**NPWS comments - Julius Avenue Data Centre (SSD- 80018208) – Amendment Report**

## Attachment A – NPWS comments on Julius Avenue Data Centre (SSD-80018208)

Figure 18: Map of Proposed New Interim Feeder & on site STSS Arrangement

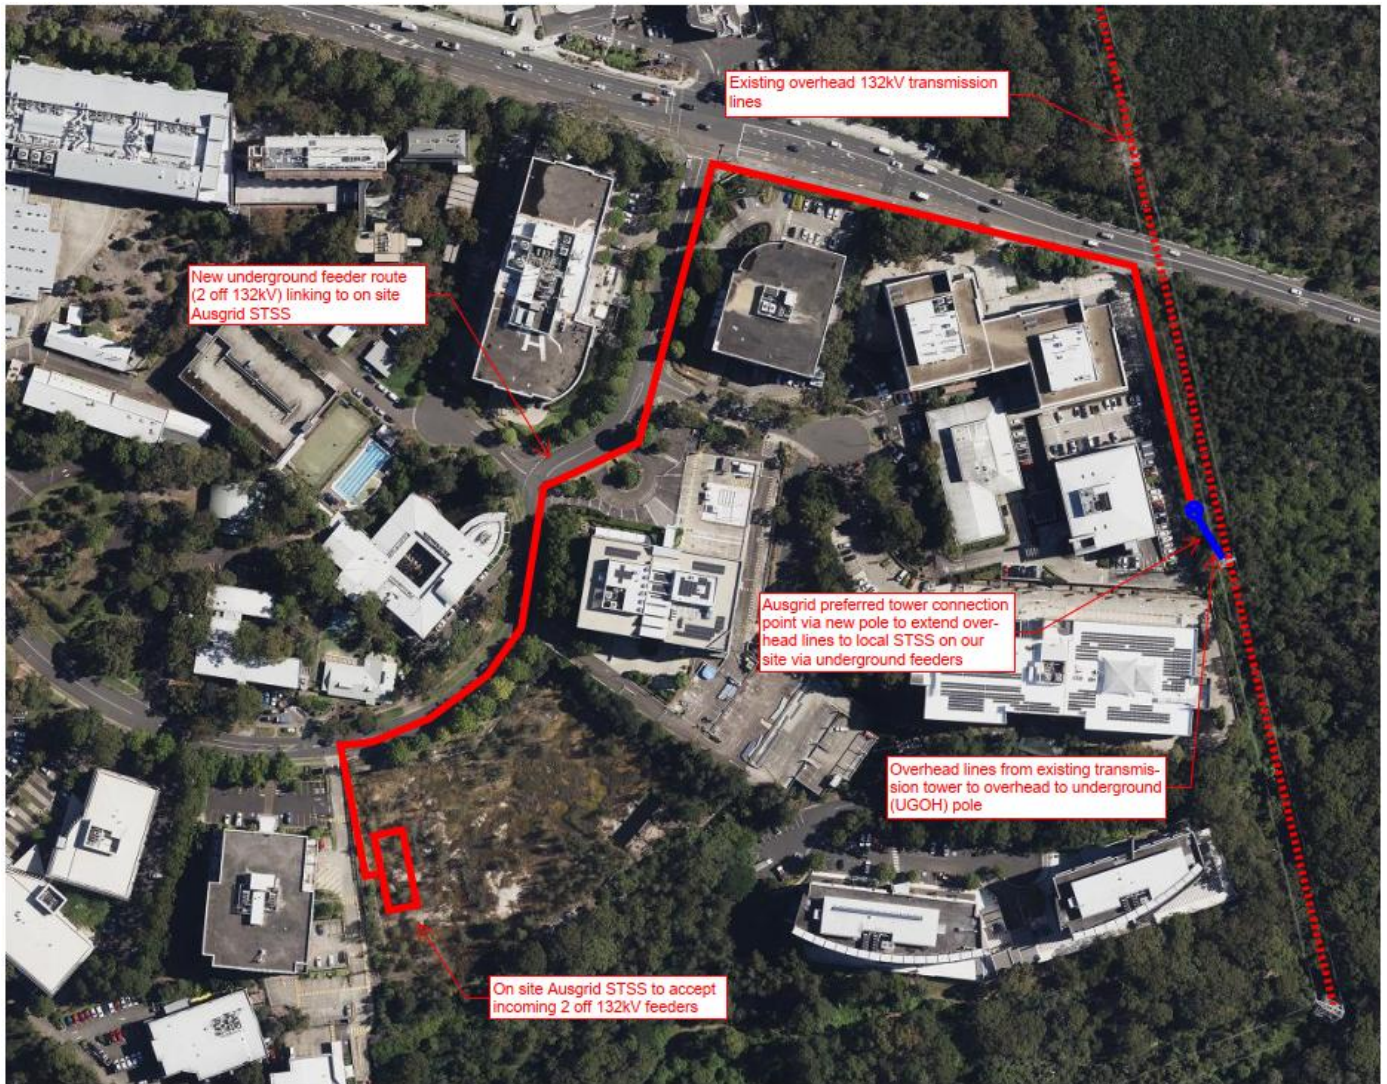
NPWS however raises concerns with the proposed High-Voltage (HV) connection, as detailed in the Infrastructure Delivery, Management & Staging Plan (Appendix DD29), as works are proposed to the existing 132 kV transmission line which sits within Lane Cove National Park. Neither the EIS nor Amendment Report provide an assessment of the likely impacts or acknowledge that works on land reserved under the NPW Act requires approval under the Act and the *National Parks and Wildlife Regulation 2019*.

| NPWS Issue 1     | Proposed HV connection                                                                                                                                                                                                                                                                                                                                                                                                                                                                                                                                                                                                                                                                                                                                                                                                                                                                                                                                                                                                                                                                                                                                                                                                                                                                             |
|------------------|----------------------------------------------------------------------------------------------------------------------------------------------------------------------------------------------------------------------------------------------------------------------------------------------------------------------------------------------------------------------------------------------------------------------------------------------------------------------------------------------------------------------------------------------------------------------------------------------------------------------------------------------------------------------------------------------------------------------------------------------------------------------------------------------------------------------------------------------------------------------------------------------------------------------------------------------------------------------------------------------------------------------------------------------------------------------------------------------------------------------------------------------------------------------------------------------------------------------------------------------------------------------------------------------------|
| <b>Detail</b>    | <p>NPWS has reviewed the Infrastructure Delivery, Management &amp; Staging Plan (IDMSP), prepared by IGS dated 19 December 2025, which discusses three potential options for HV connection to the site. In Section 6.1, it is suggested that the preferred option to satisfy the timing of the project is to establish 2 new feeders (132kV) from the existing overhead 132kV transmission towers adjacent to the site. The details of Option 3 are elaborated in Section 4.2, which confirms that the connection arrangement will involve a new pole to be installed near the existing transmission tower for the conversion of overhead to underground cabling. However, the IDMSP nor AR acknowledge that this HV connection will require works within Lane Cove National Park.</p> <p>NPWS highlights that the existing overheard 132 kV transmission line is located within the adjacent National Park, and any augmentation or connection to this asset will require approval under both the <i>National Parks and Wildlife Act 1974</i> and <i>National Parks and Wildlife Regulation 2019</i>.</p> <p>NPWS has not been provided with a scope of works or assessment of likely impacts of this component of the proposal, which appears essential to the operation of the data centre.</p> |

| NPWS Issue 1     | Proposed HV connection                                                                                                                                                                                                                                                                                                                                                                                                                                                                                                                                                                                                                                                                                                                                                                                                                                                                                                                                                                                                                                                                                                                                                                                                                                                                             |
|------------------|----------------------------------------------------------------------------------------------------------------------------------------------------------------------------------------------------------------------------------------------------------------------------------------------------------------------------------------------------------------------------------------------------------------------------------------------------------------------------------------------------------------------------------------------------------------------------------------------------------------------------------------------------------------------------------------------------------------------------------------------------------------------------------------------------------------------------------------------------------------------------------------------------------------------------------------------------------------------------------------------------------------------------------------------------------------------------------------------------------------------------------------------------------------------------------------------------------------------------------------------------------------------------------------------------|
| <b>Recommend</b> | <p>DPHI requests an assessment of likely impacts relating to the proposed HV connection.</p> <p>NPWS highlights that any works proposed within Lane Cove National Park will require approval under both the <i>National Parks and Wildlife Act 1974</i> and <i>National Parks and Wildlife Regulation 2019</i>.</p>                                                                                                                                                                                                                                                                                                                                                                                                                                                                                                                                                                                                                                                                                                                                                                                                                                                                                                                                                                                |
